CITY OF PORTLAND

May 25, 2001

RE: 105-107 India St. (020 A008)

With regard to your waiver request dated 4/12/01, the following is the disposition:

REVISED 1<sup>ST</sup> FLOOR PLAN

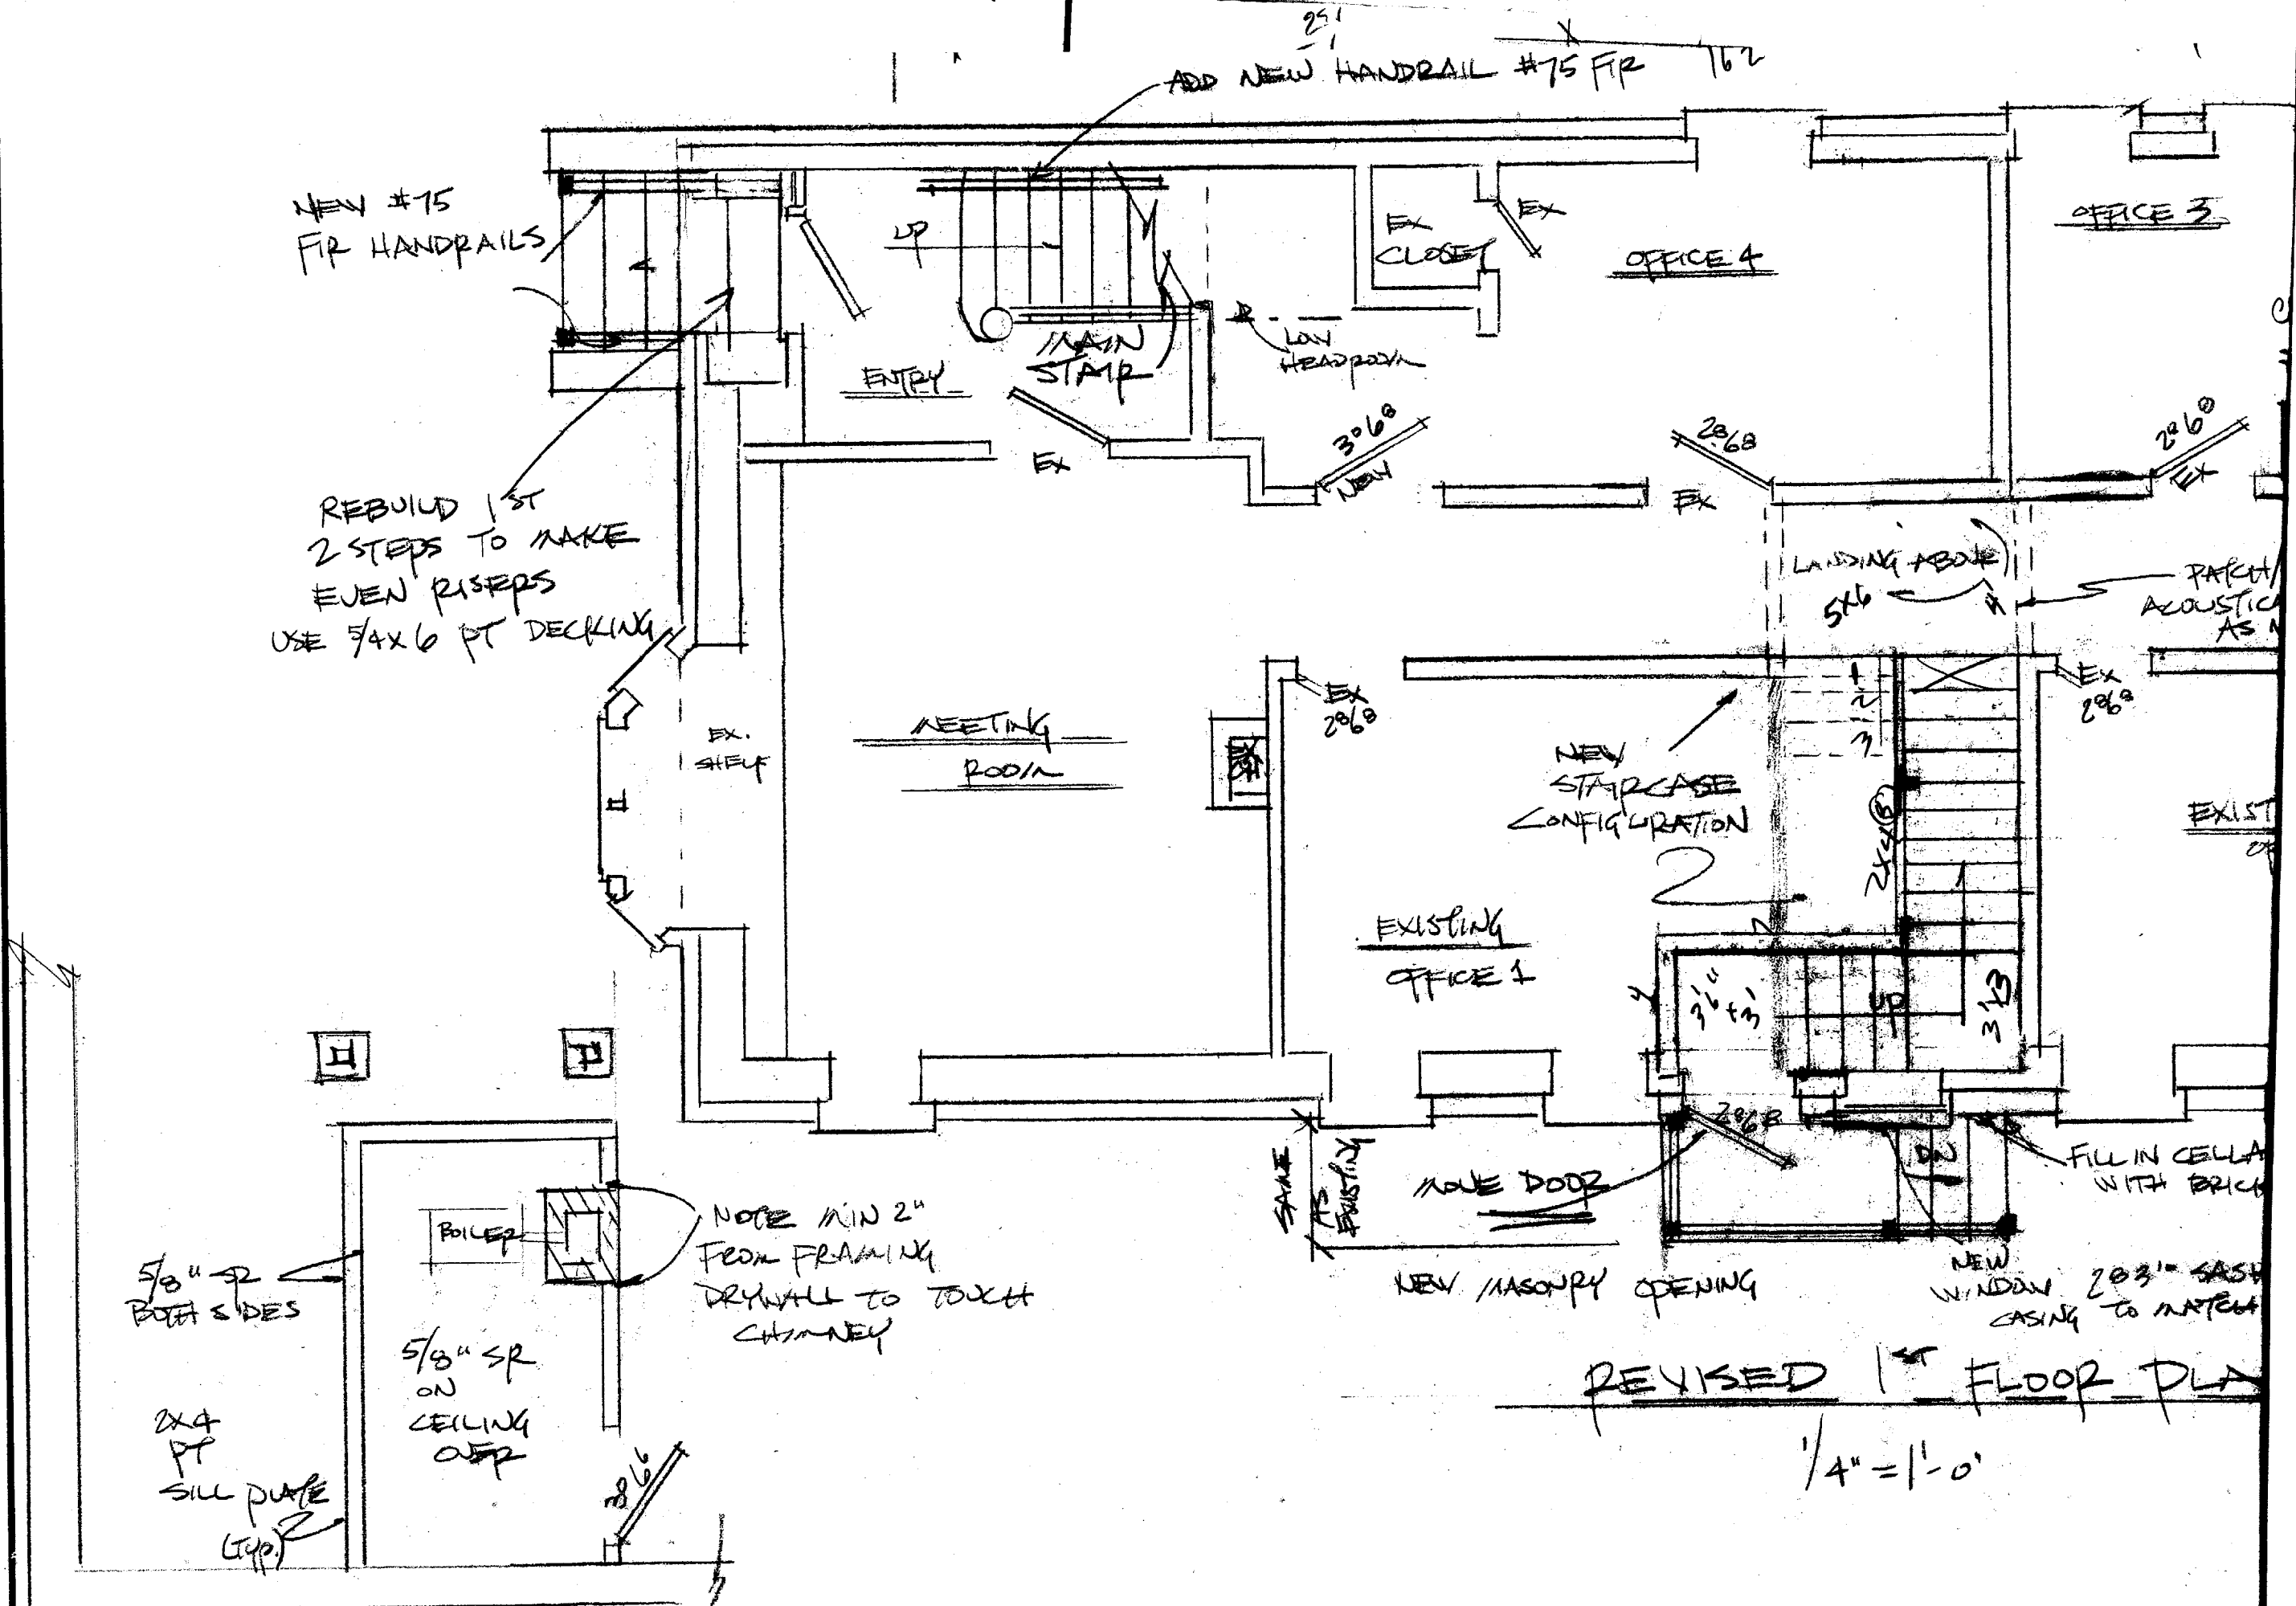
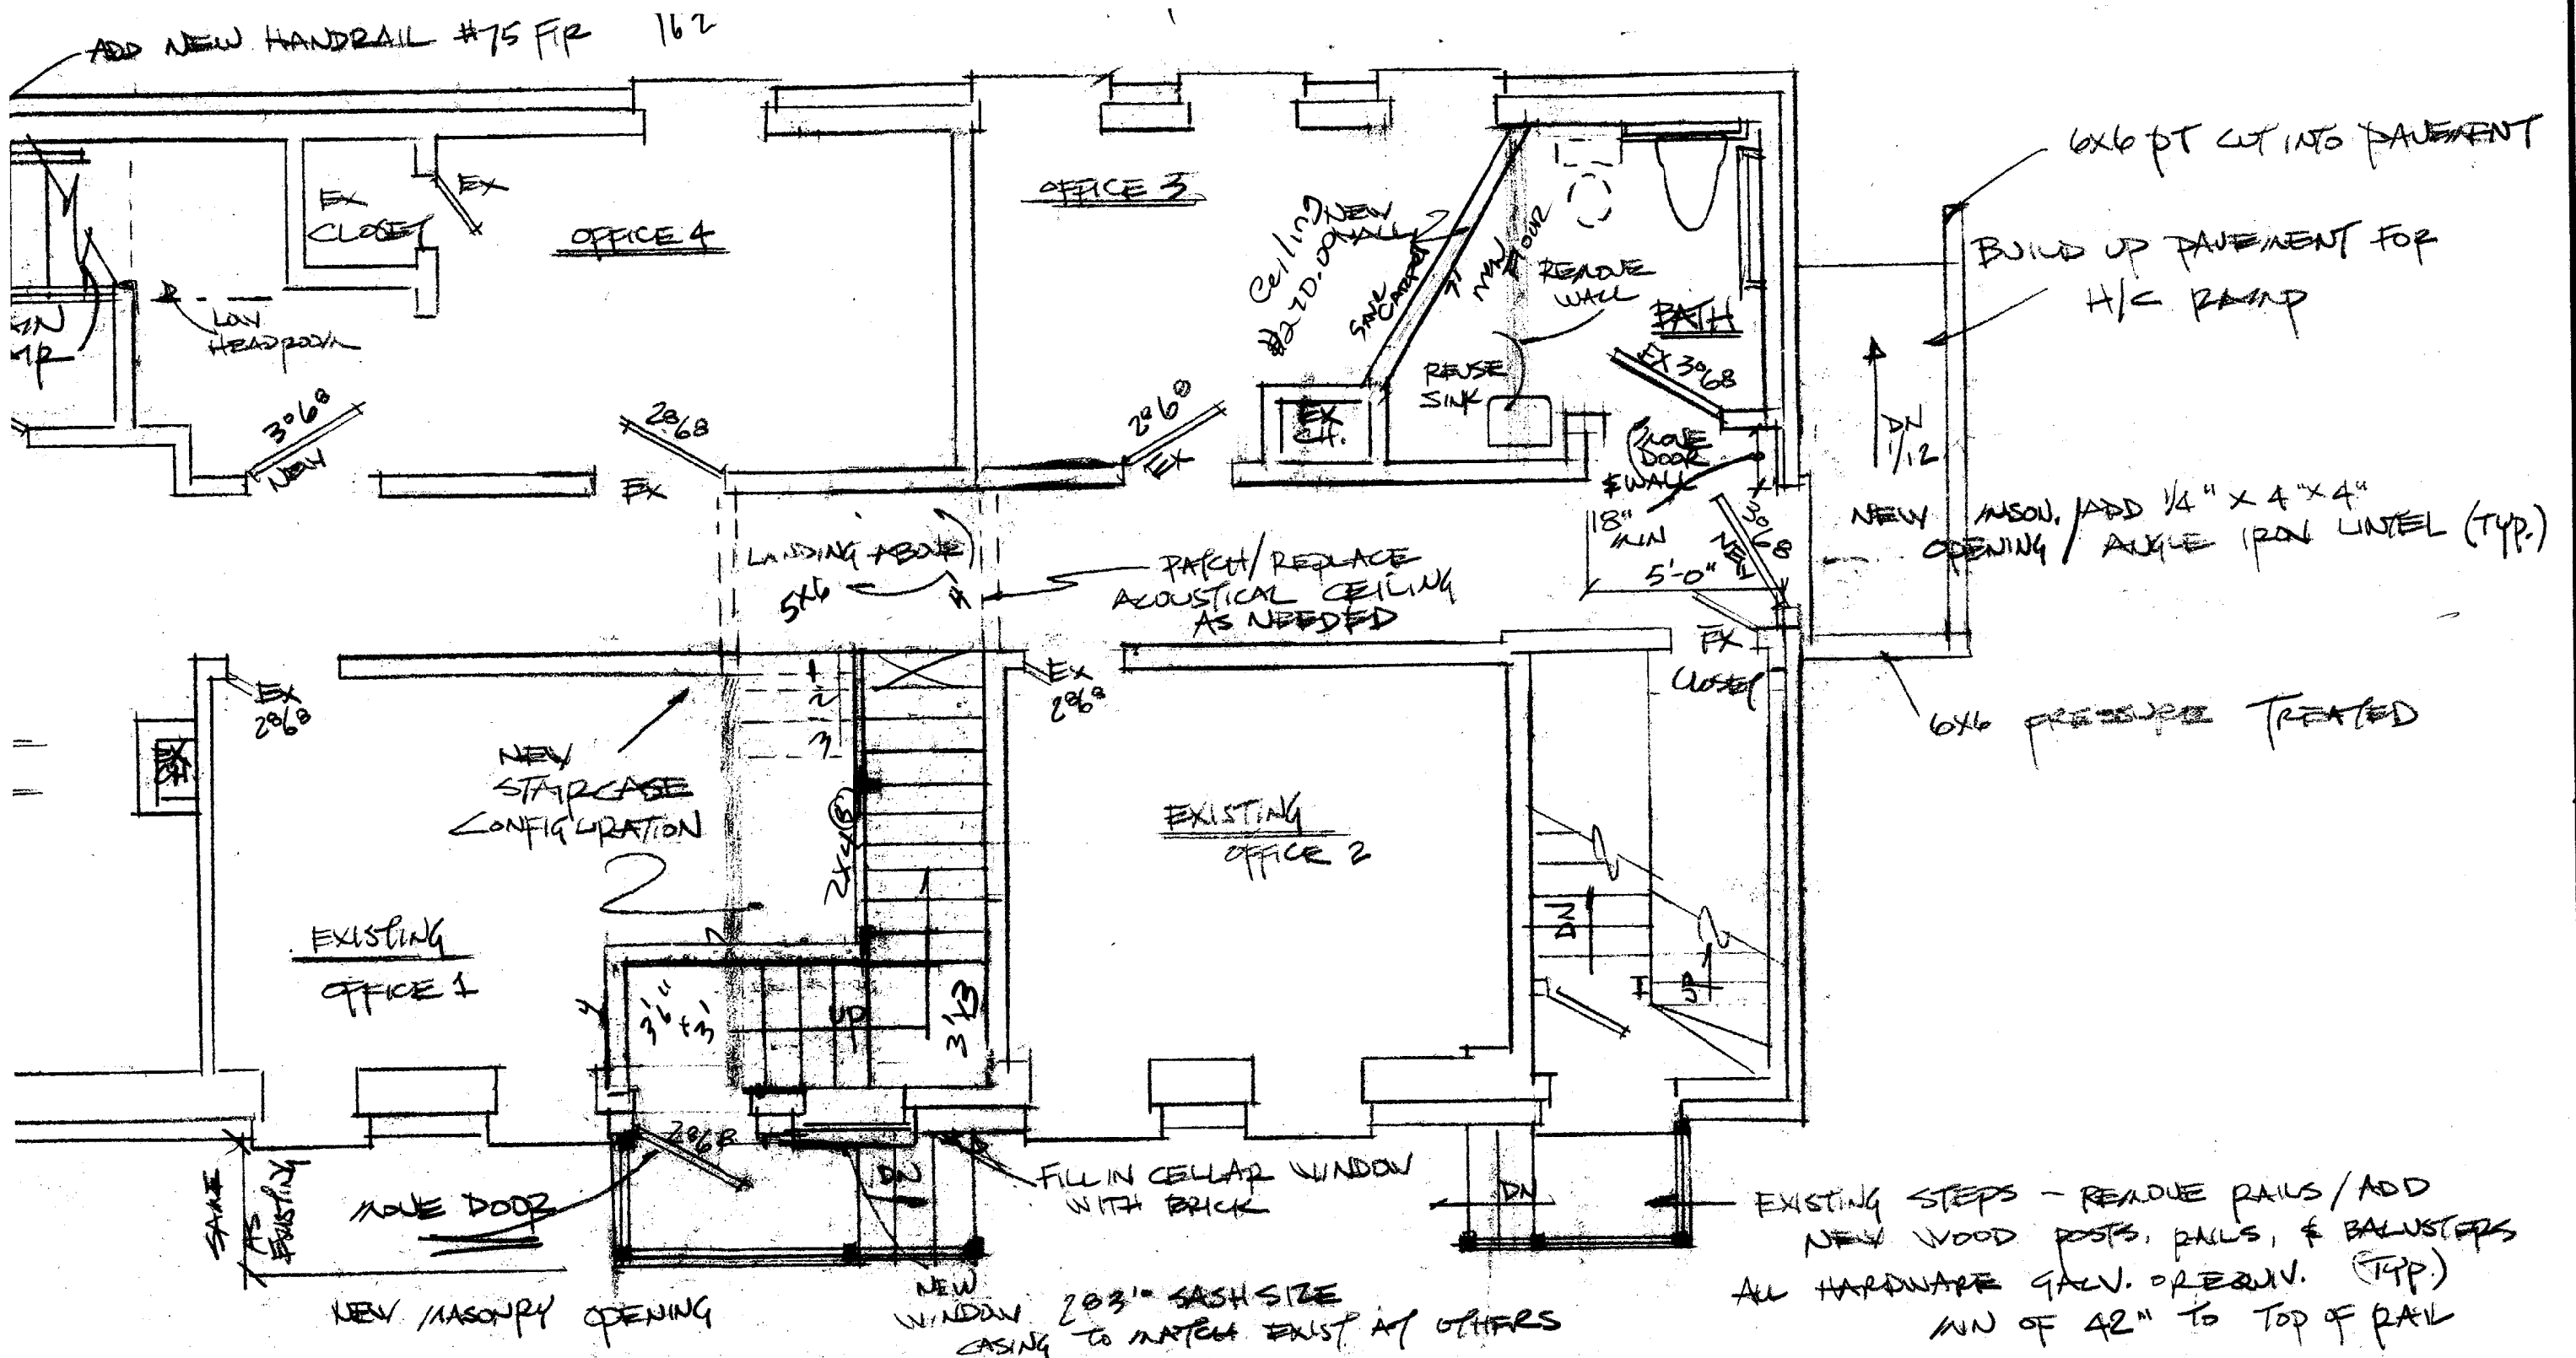
Request # 2. Headroom adjustment in the 1st floor office hallway of 6' 10" for an area 12" X 17" is approved.

STAIR SECTION  
1/2" = 1'-0"

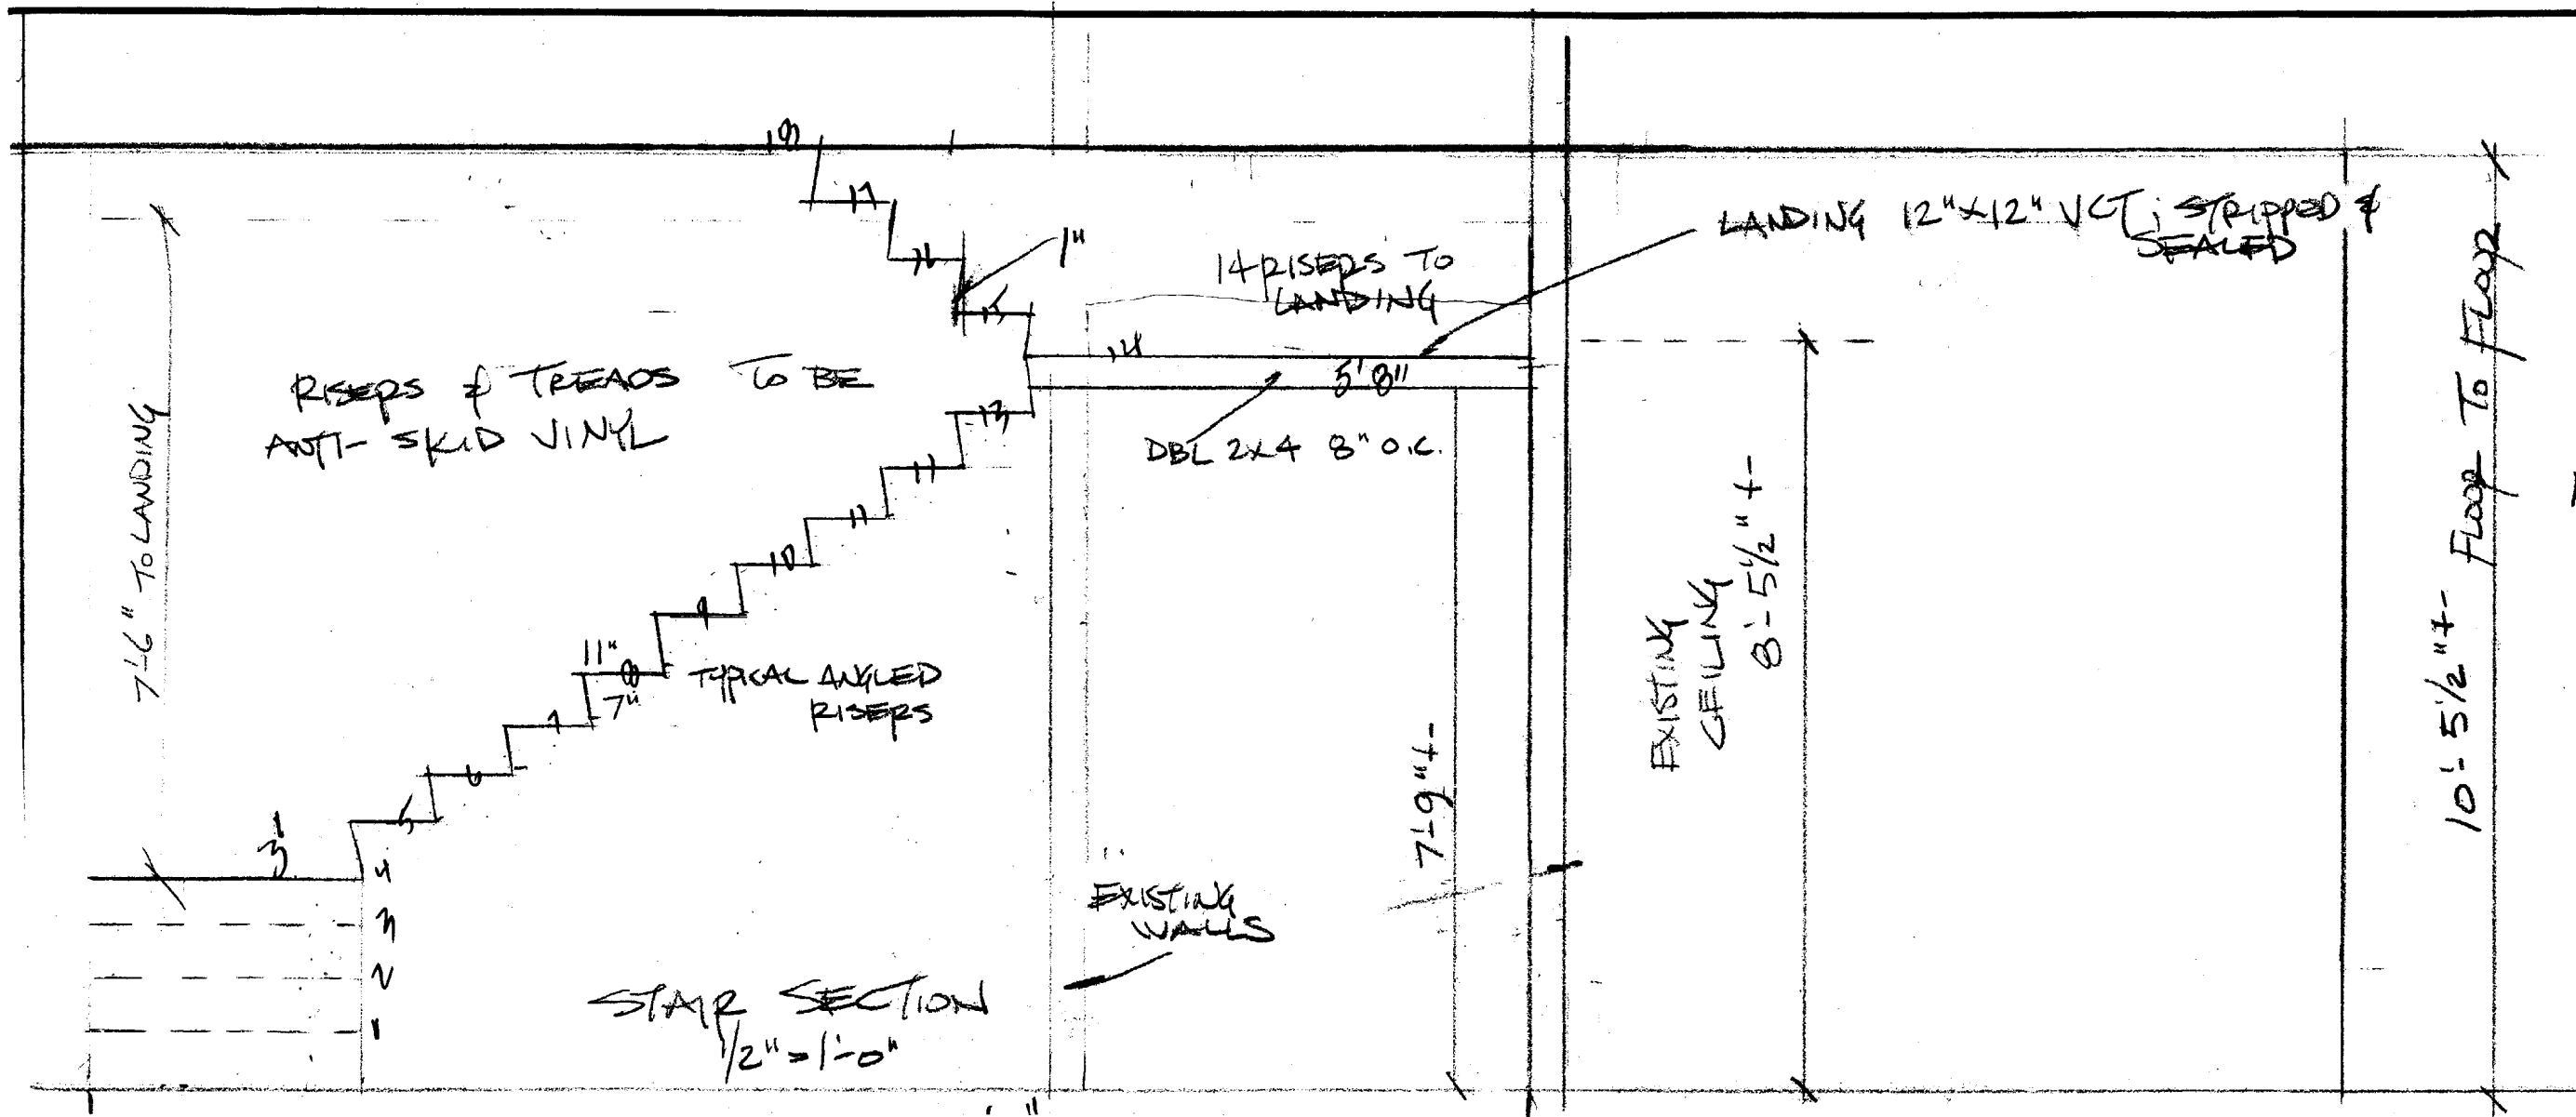
Request # 1. Handrail Extension at 2 inches beyond the bottom riser is approved as the railing would terminate into a doorway at required 11 inch termination. The 2" rail must return to the wall as required by Code.
